Application for a non-material amendment following a grant of planning permission.

Number	14
Suffix	
Property name	
Address line 1	Davenport Road
Address line 2	
Address line 3	
Town/city	Felpham
Postcode	PO22 7JR
Description of site location must be completed if postcode is not known:	
Easting (x)	495422
Northing (y)	99519
Description

Hip to gable loft conversion with juliet balcony, alterations to fenestration/openings and external facade.

Reference number:	FP/113/21/HH
Date of decision	19/07/2021

Dwg No. 21009-P-107-D

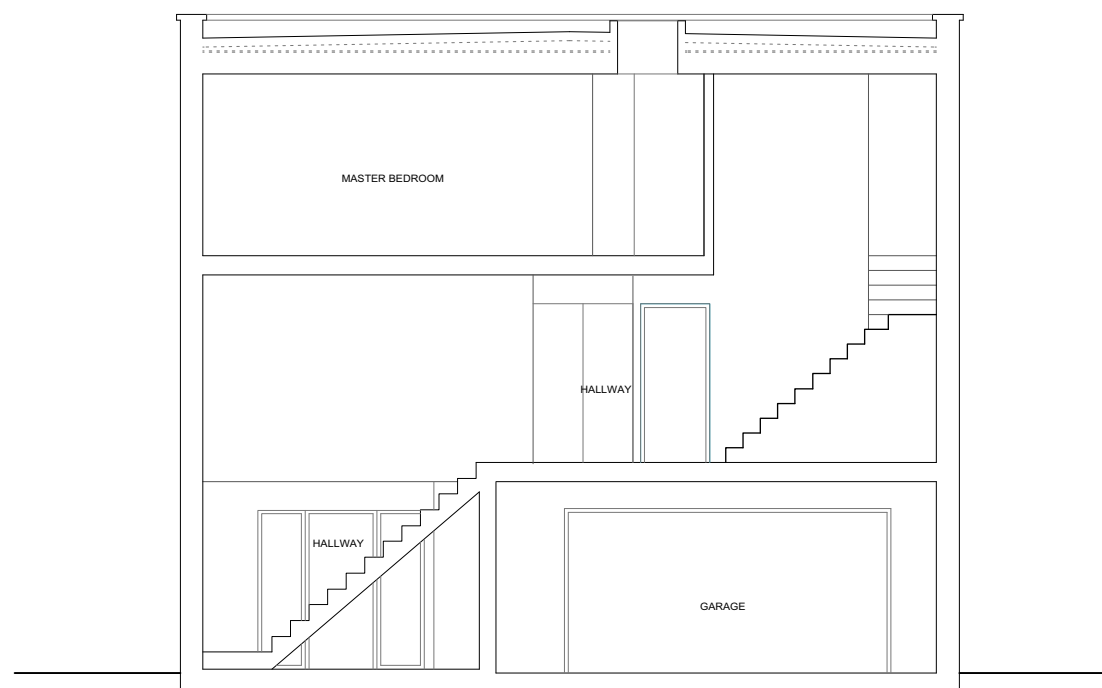
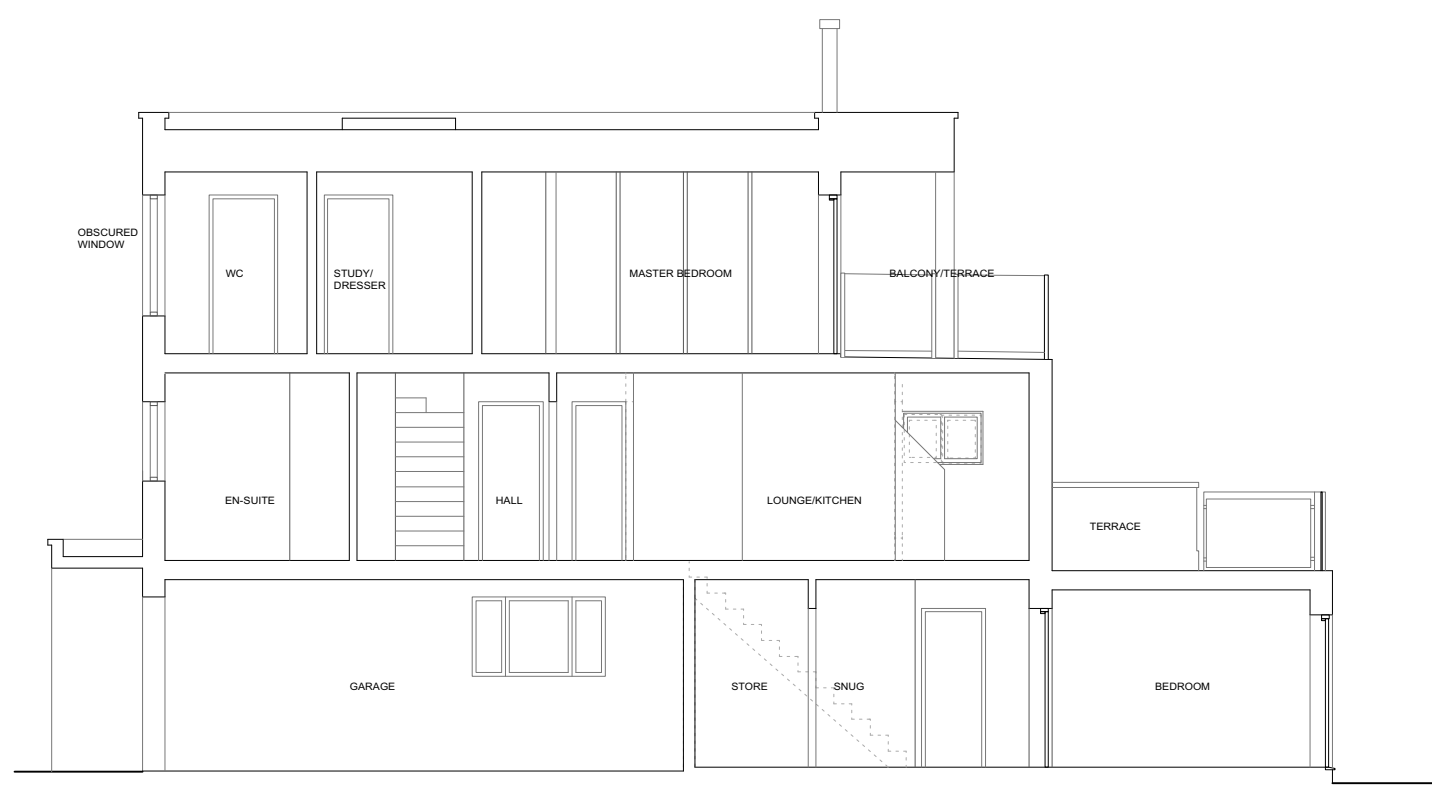
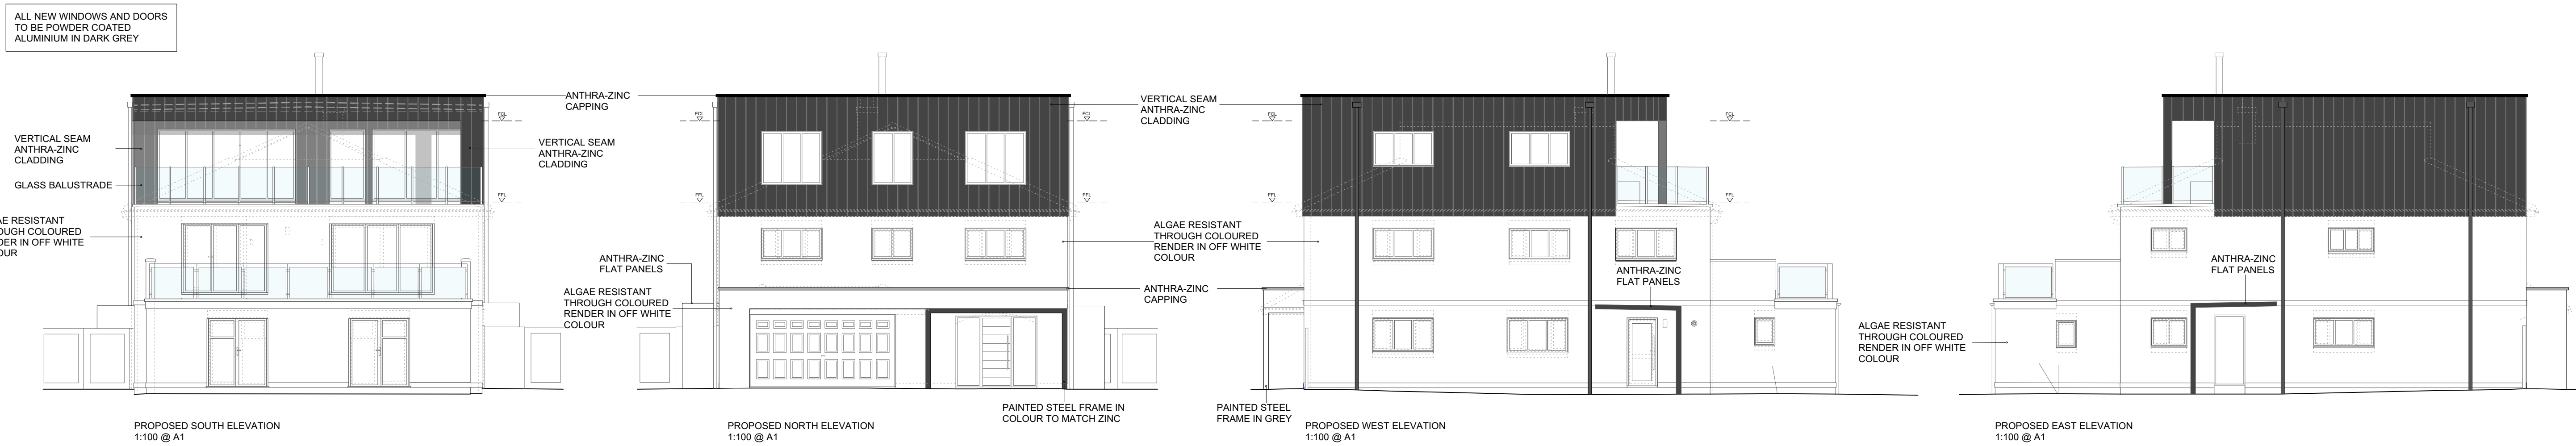
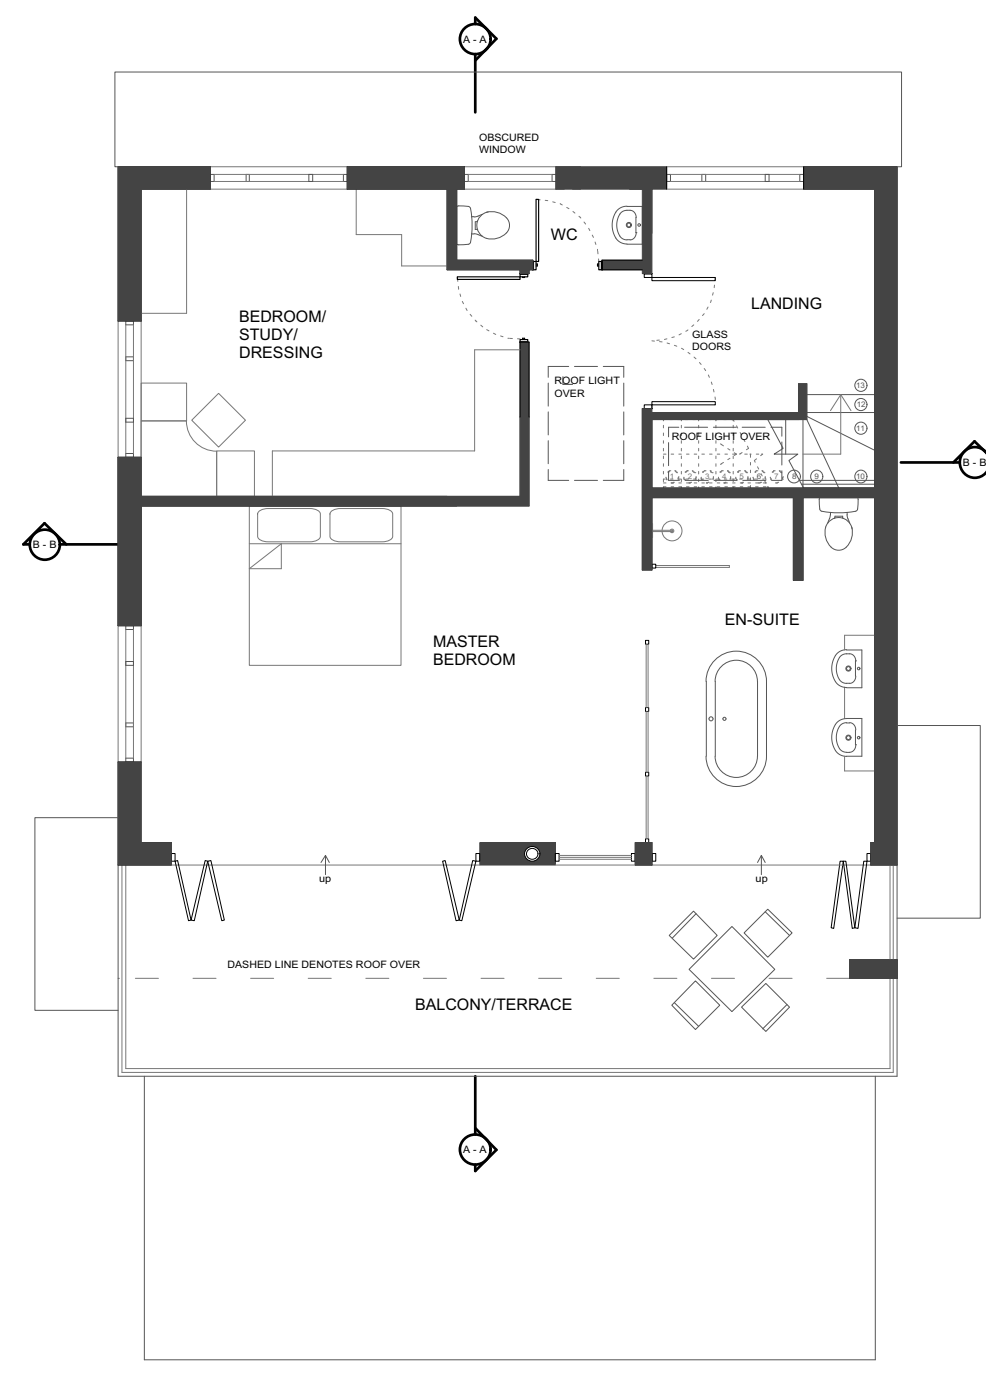
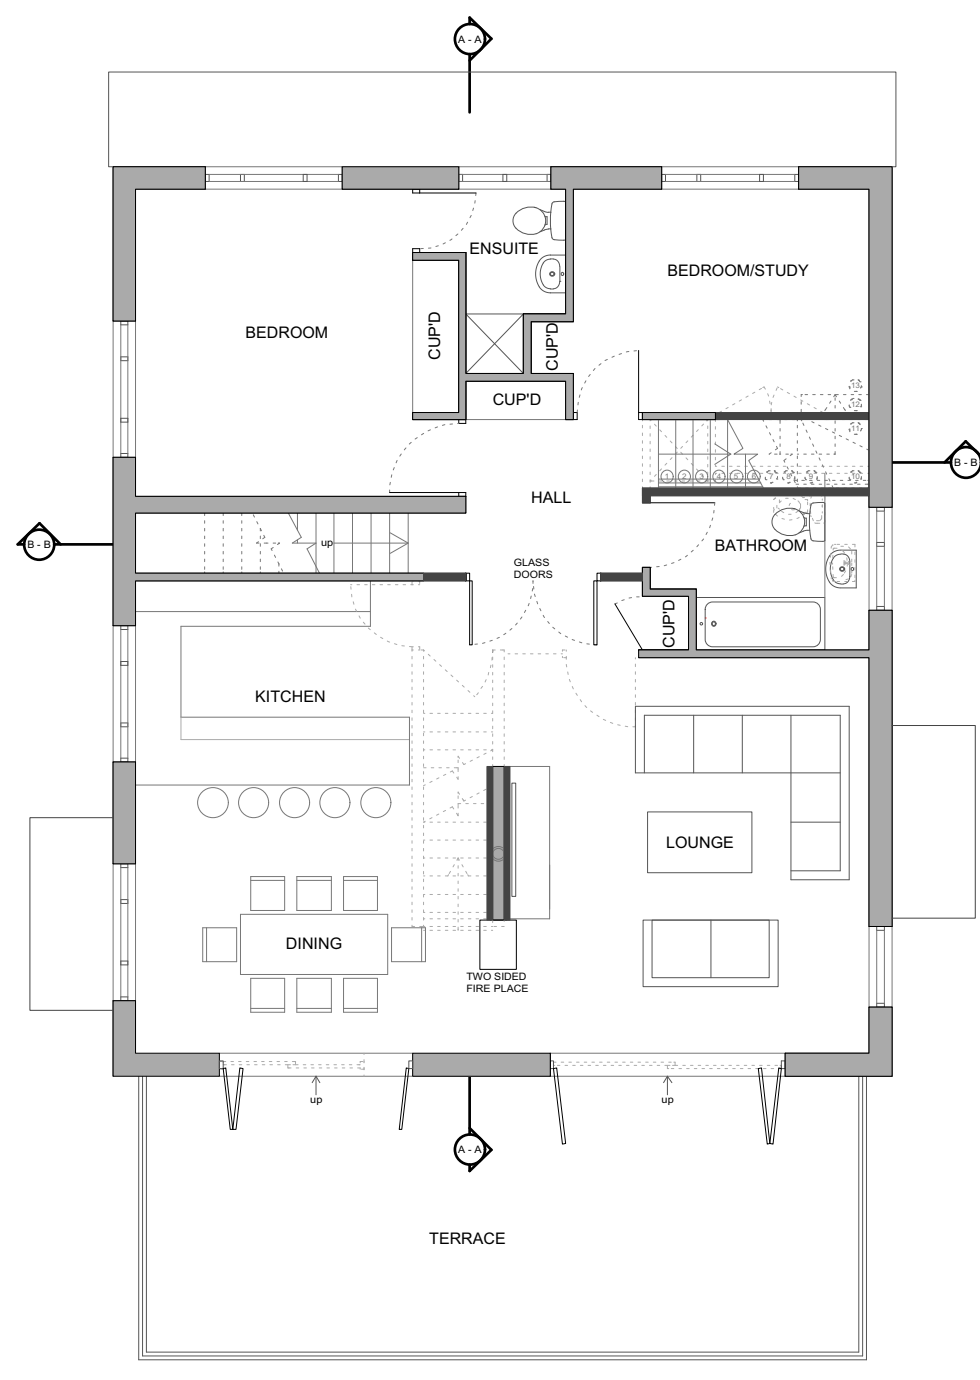
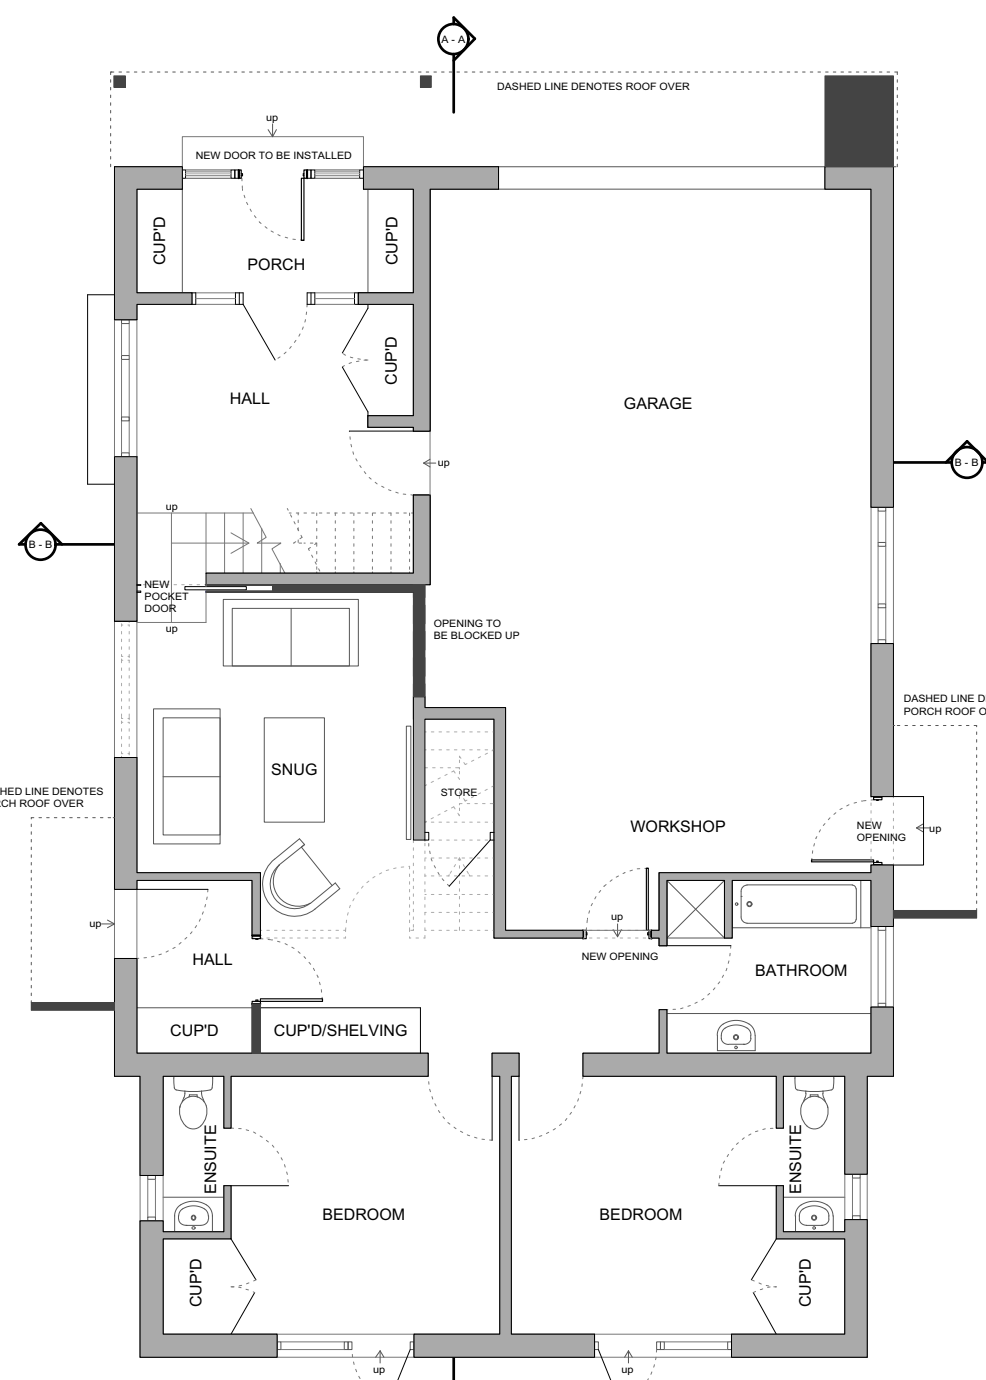
Increasing structural openings of the windows on the first and second floors on the south elevation. Raising second-floor balcony.

The windows are widened to create symmetry and balance the elevation. The balcony is raised to allow for level access from the master bedroom.
